From: Philip Goacher Associates [REDACTED]
Sent: 24 February 2022 09:38
To: Nicola Moore
Subject: Re: WA/15/22/PL and WA/16/22/L - 22028 Walberton Park The Street Walberton BN18 0PJ
Attachments: 22028 - 002A Proposed - Walberton Park, The Street, Walberton.pdf

Application reference: WA/15/22/PL and WA/16/22/L.

Project No: 22028
Drawing No: 001
Revision: A

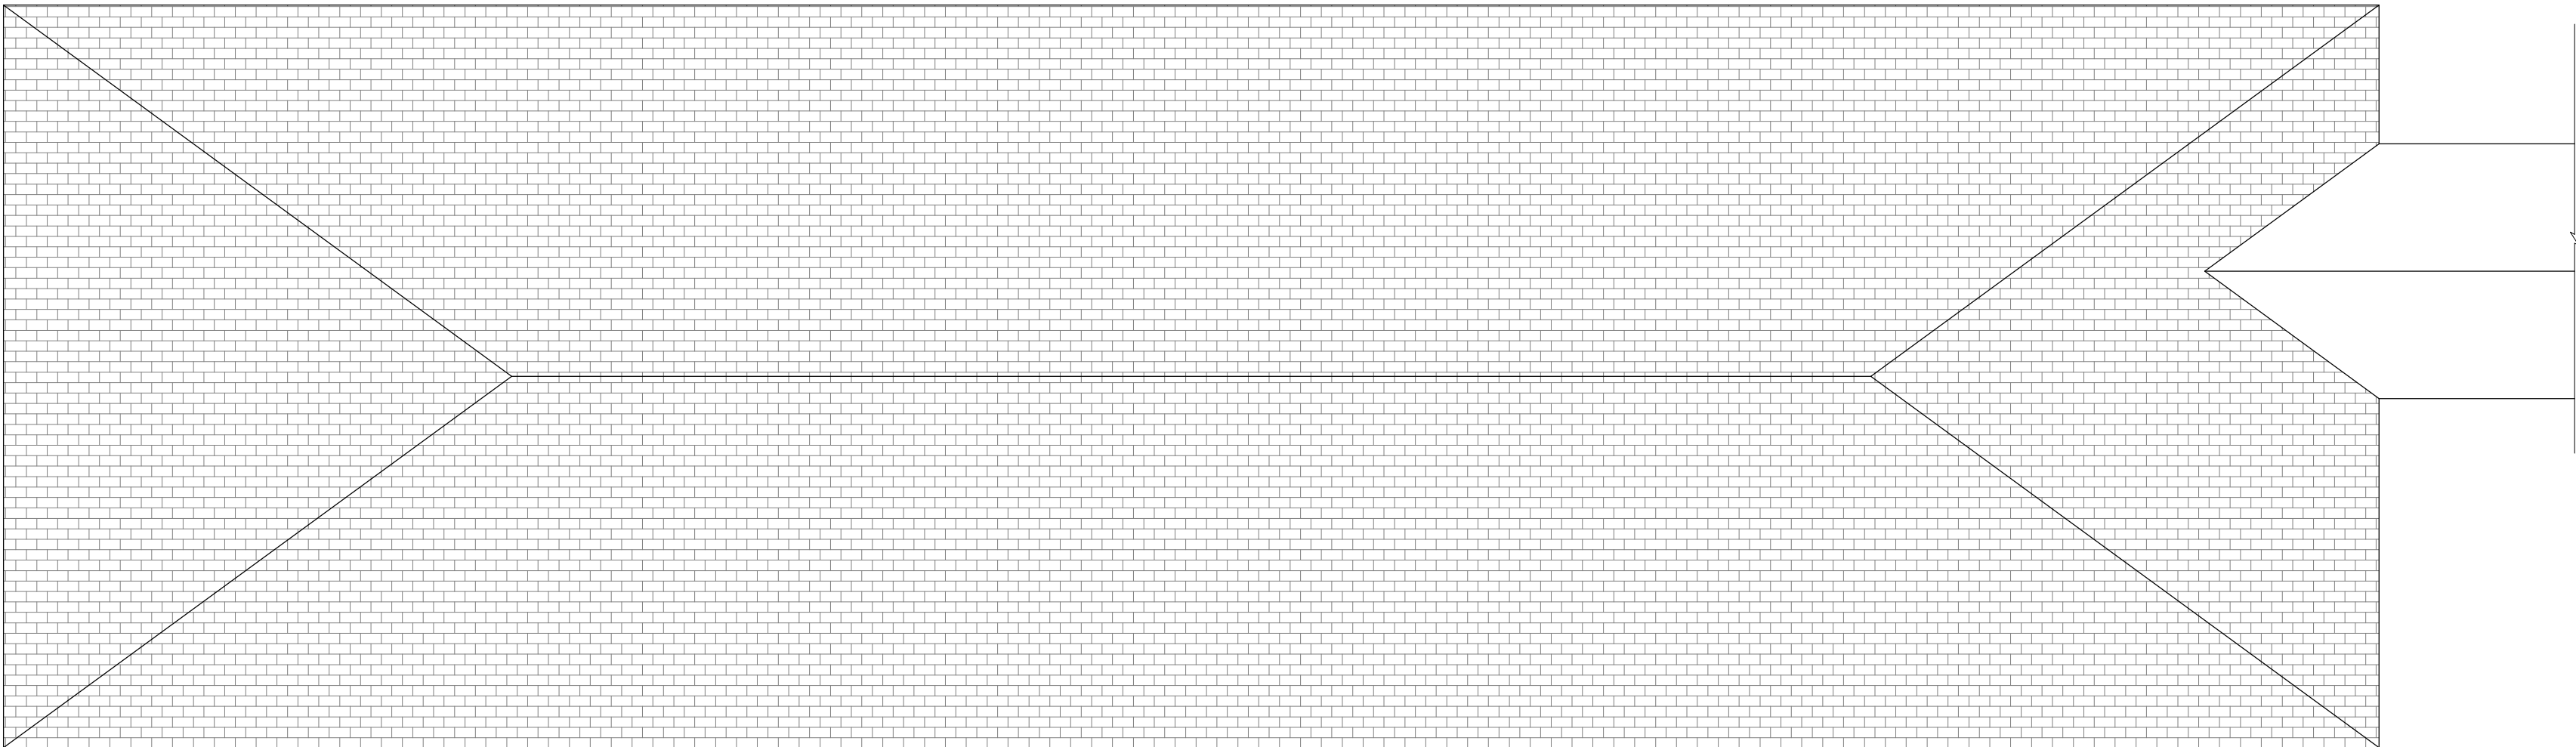
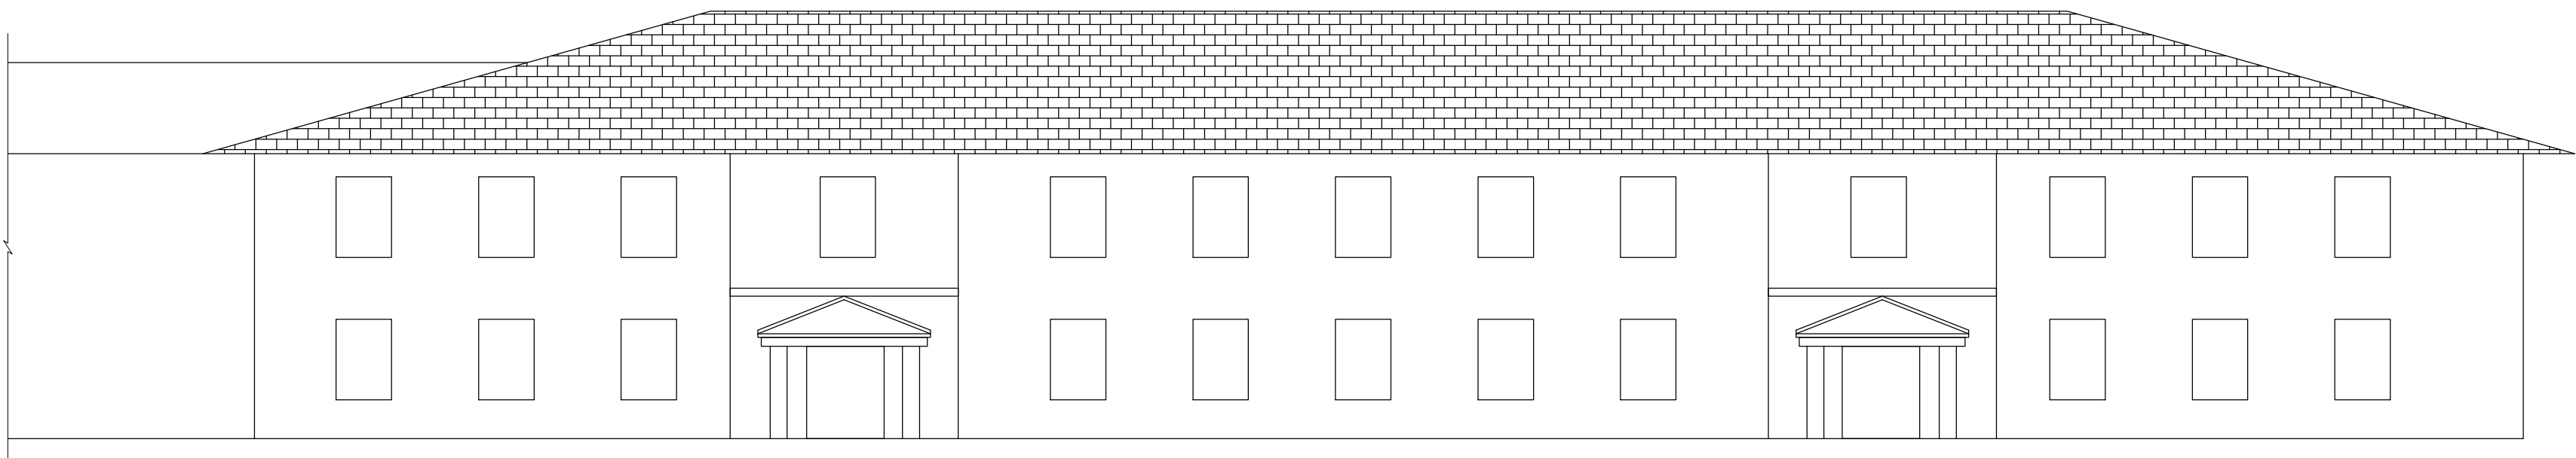
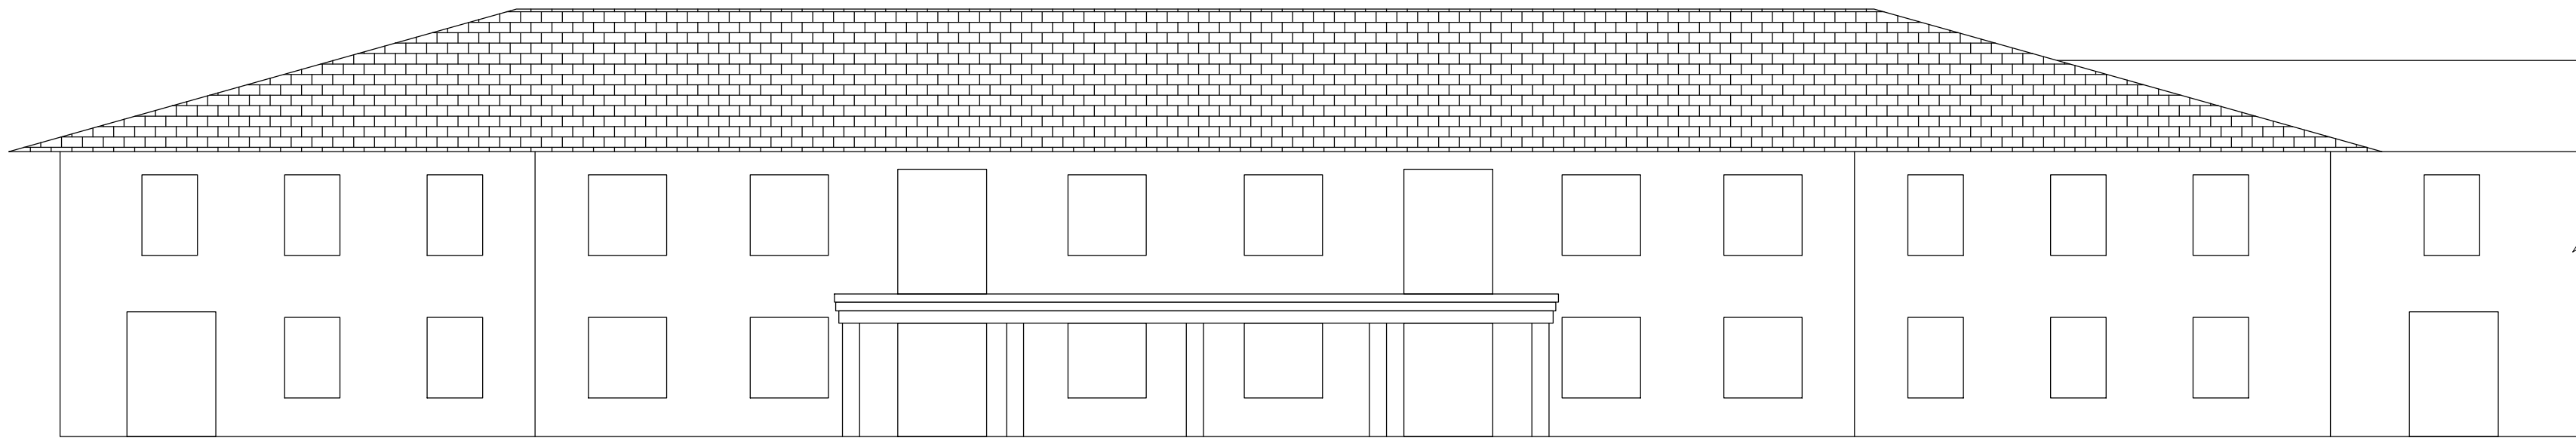
The Method statement is okay. However, I have noticed that the scale on the Existing & Proposed Elevations is 1:100, but the scale bar is 1:50. Please can you amend accordingly and re submit.

Please refer to the updated drawing no. 22028 - 001A with the 1:100 scale bar added.

Project No: 22028
Drawing No: 002
Revision: A

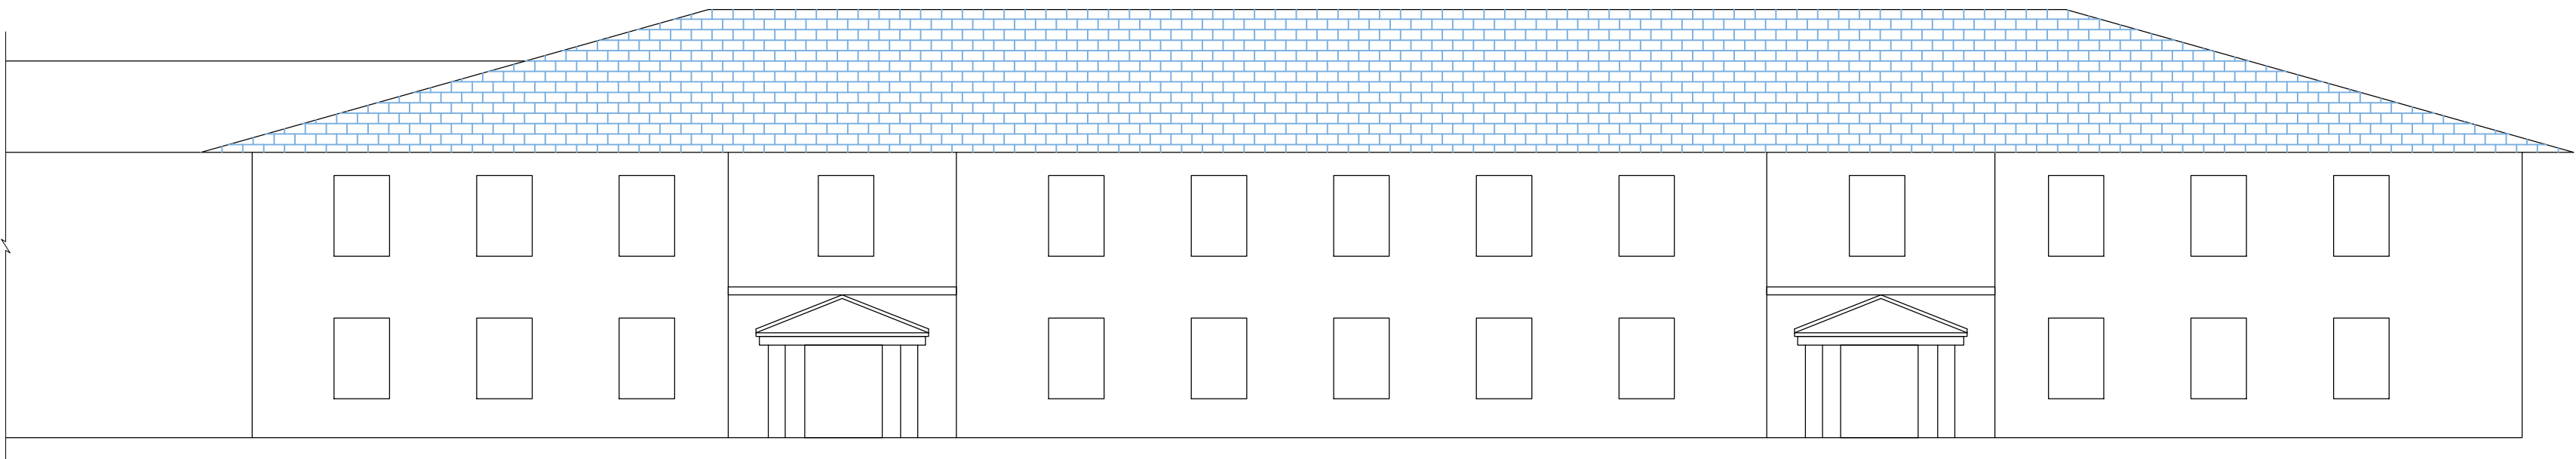
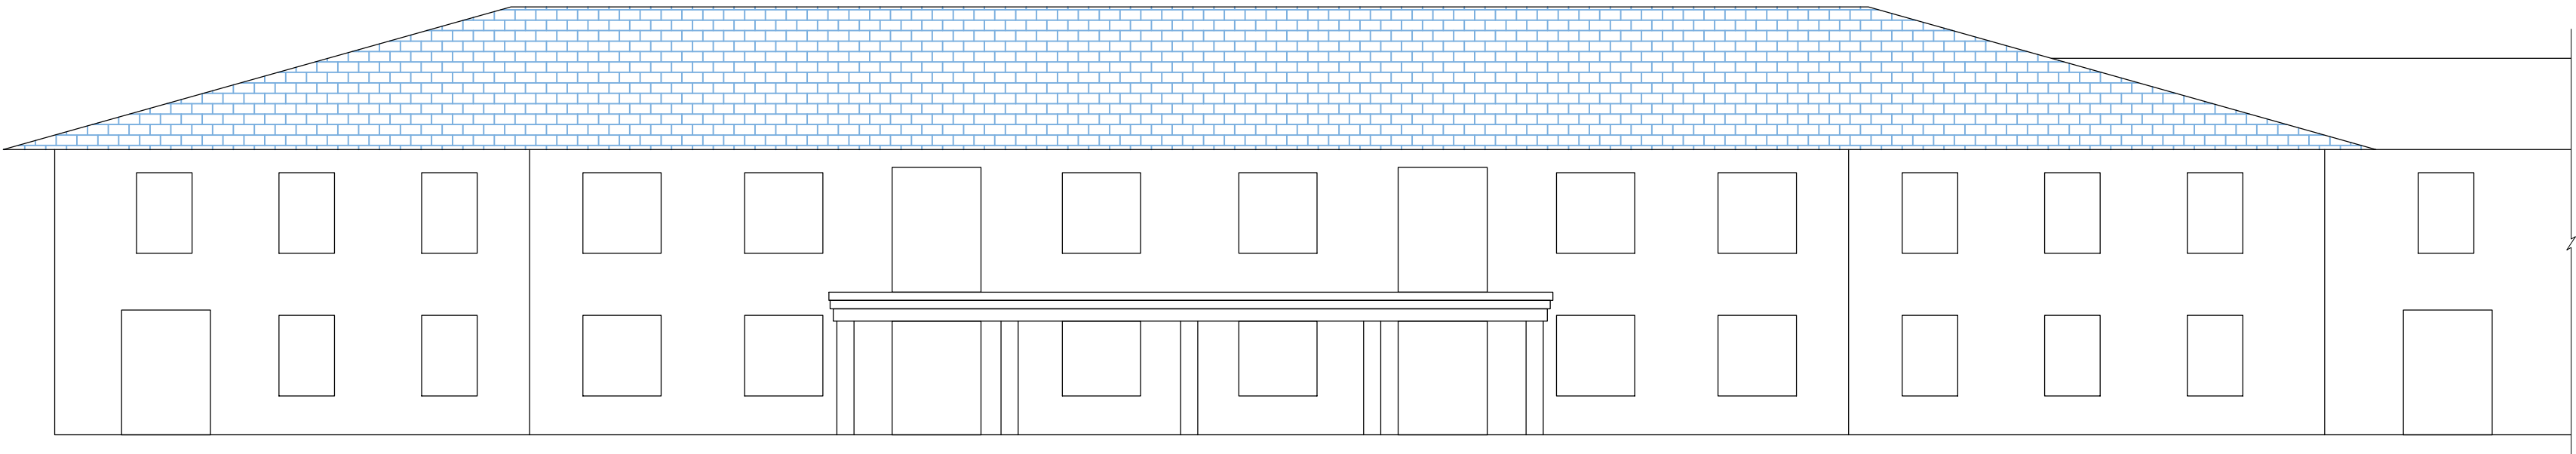
As per my email of 17th February, please could you also amend the scale bar on the Proposed Elevations.

Please refer to the attached updated Proposed drawing no. 22028 - 002A with a 1:100 scale bar.
